**Consultation Response from Trees Planning,
KC Trees****2019/91327 Thongsbridge Mills, Miry Lane, Thongsbridge, Holmfirth, HD9 7RW****Reserved matters application pursuant to outline permission no. 2017/90207 for erection of B1 light industry****Date Responded: 21/05****Responding Officer: NG****Responding Ref:41/89**

Appendix 1. Landscape Design Showing Areas of Native Planting

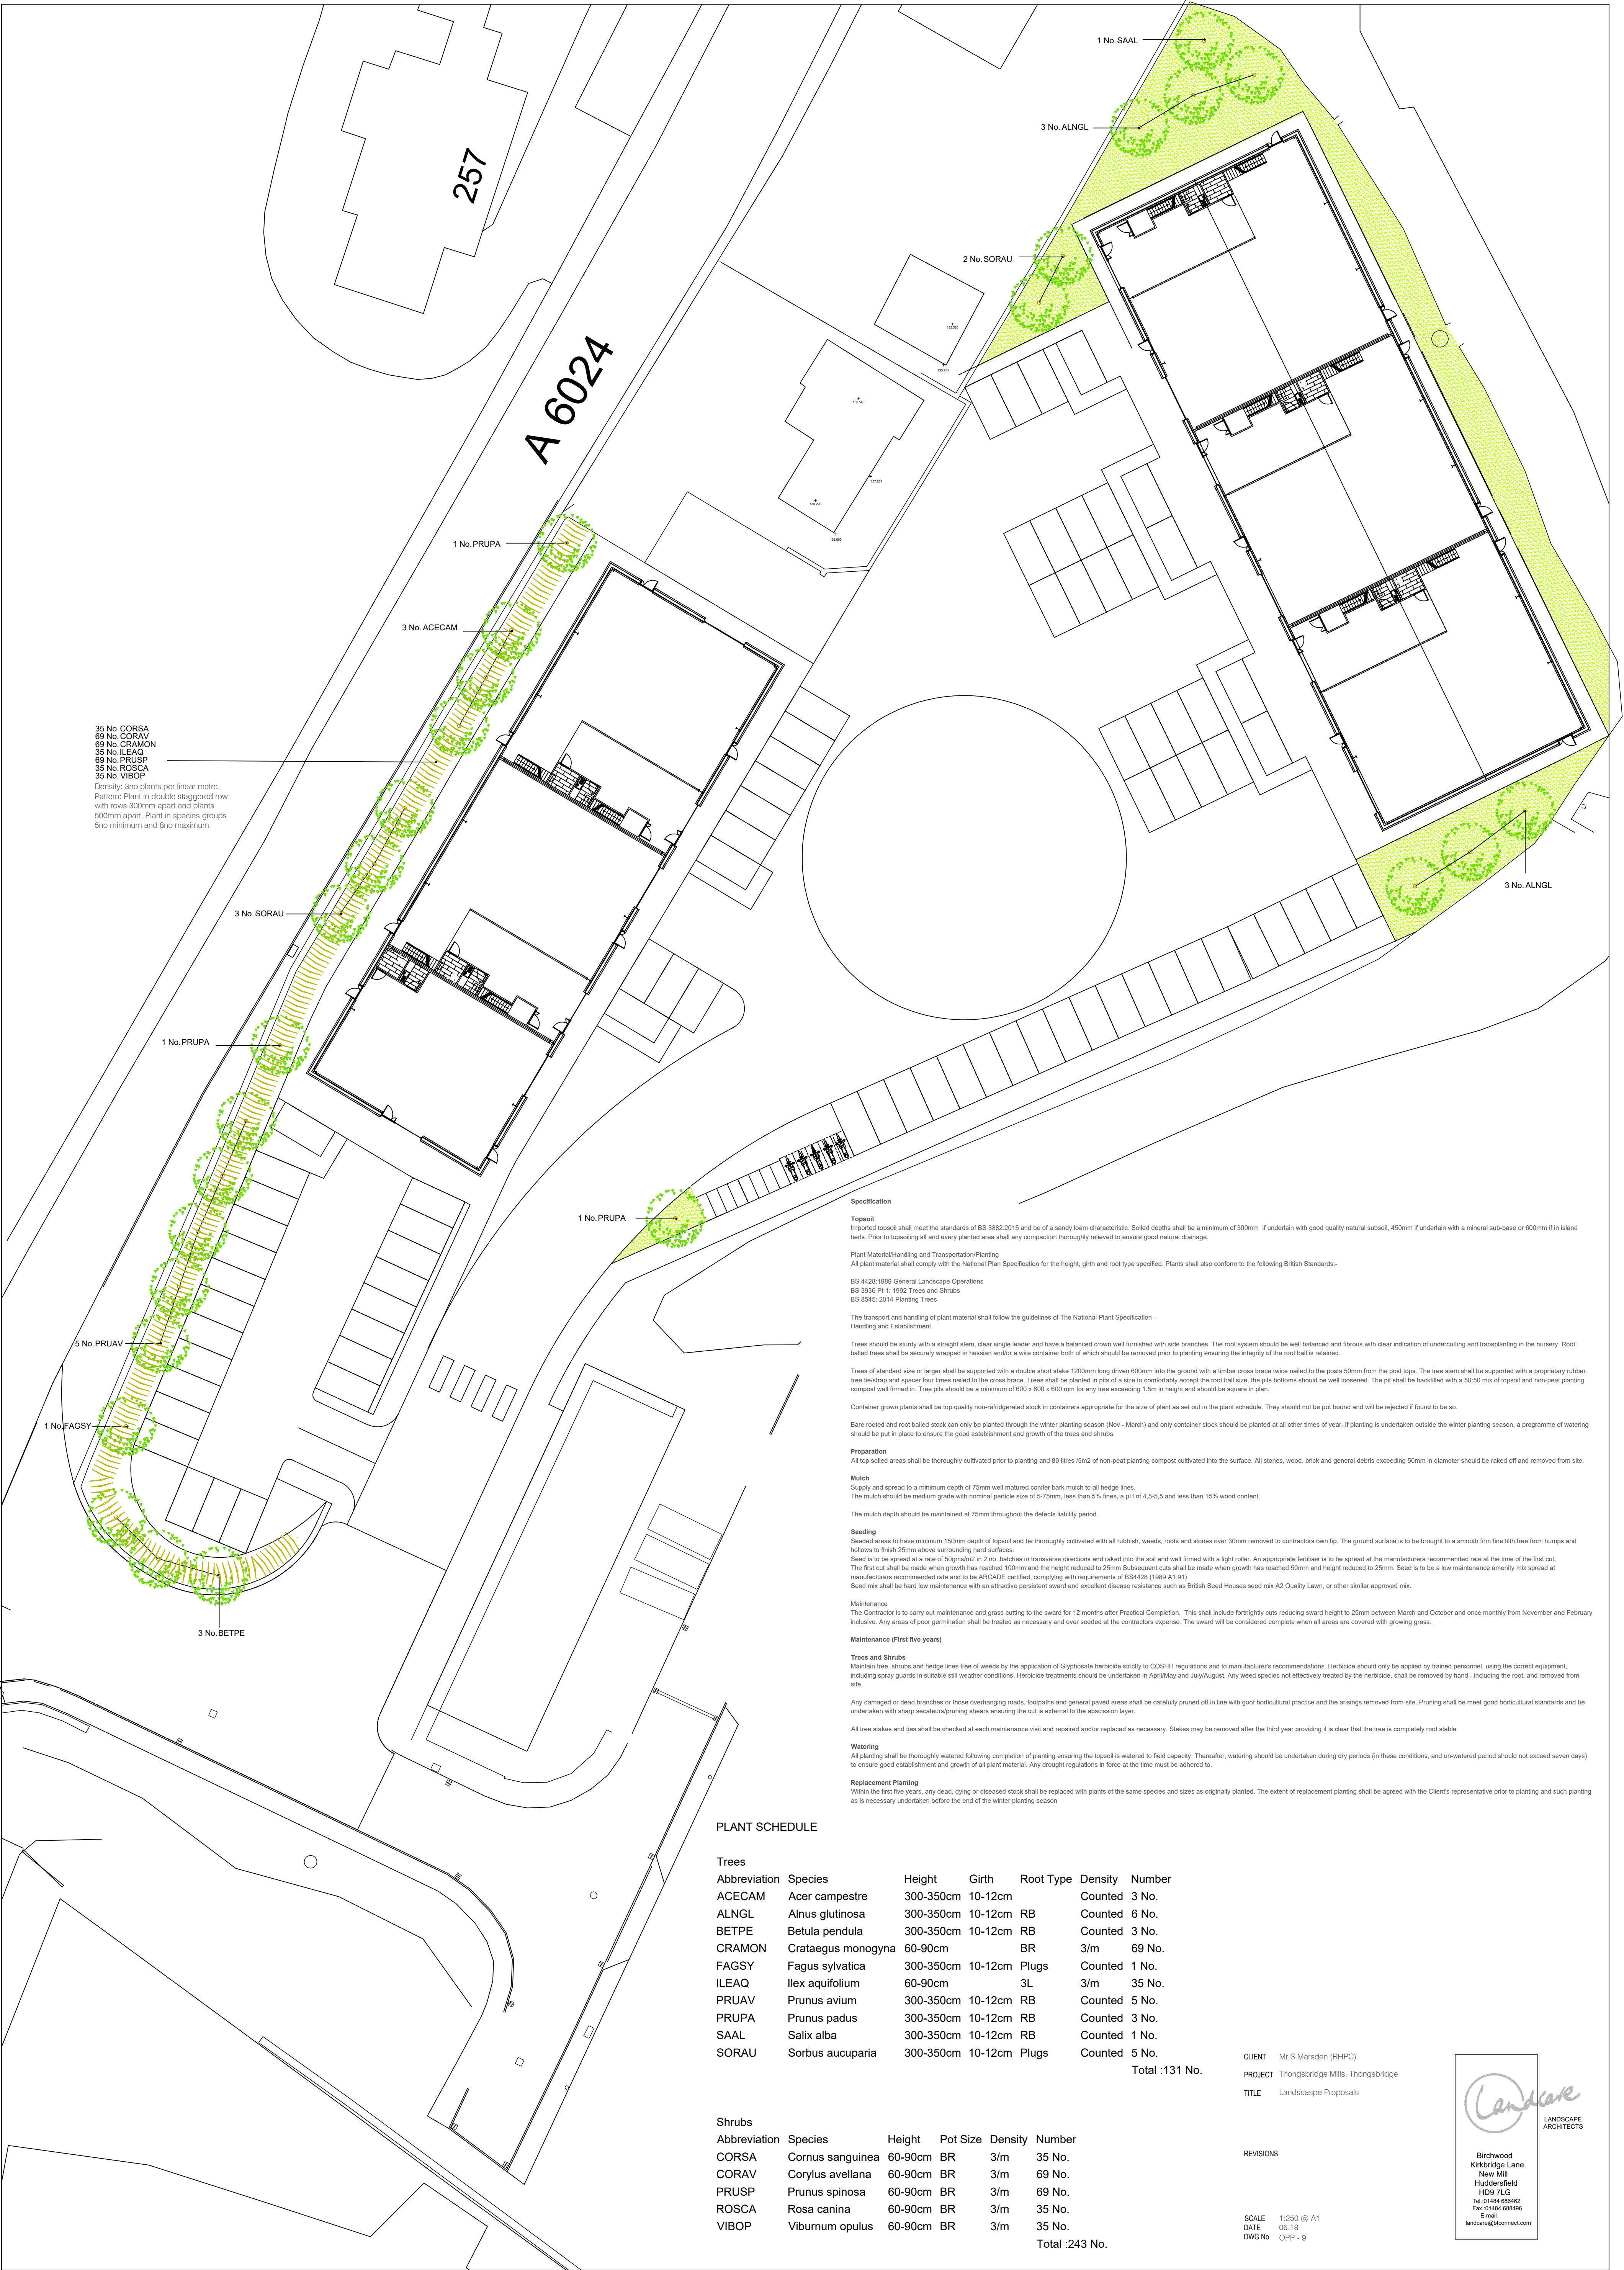
I am broadly supportive of the proposals as no protected trees will be affected by the layout. I would request that the proposed replacement planting be re-visited as the replacement trees shown are not making the most of the space and public amenity/impact they could, being smaller trees. If 3 or 4 of the trees were species capable of providing a greater amenity value such as Lime, Oak or Beech this would provide for the long term aesthetic of the site and wider area.
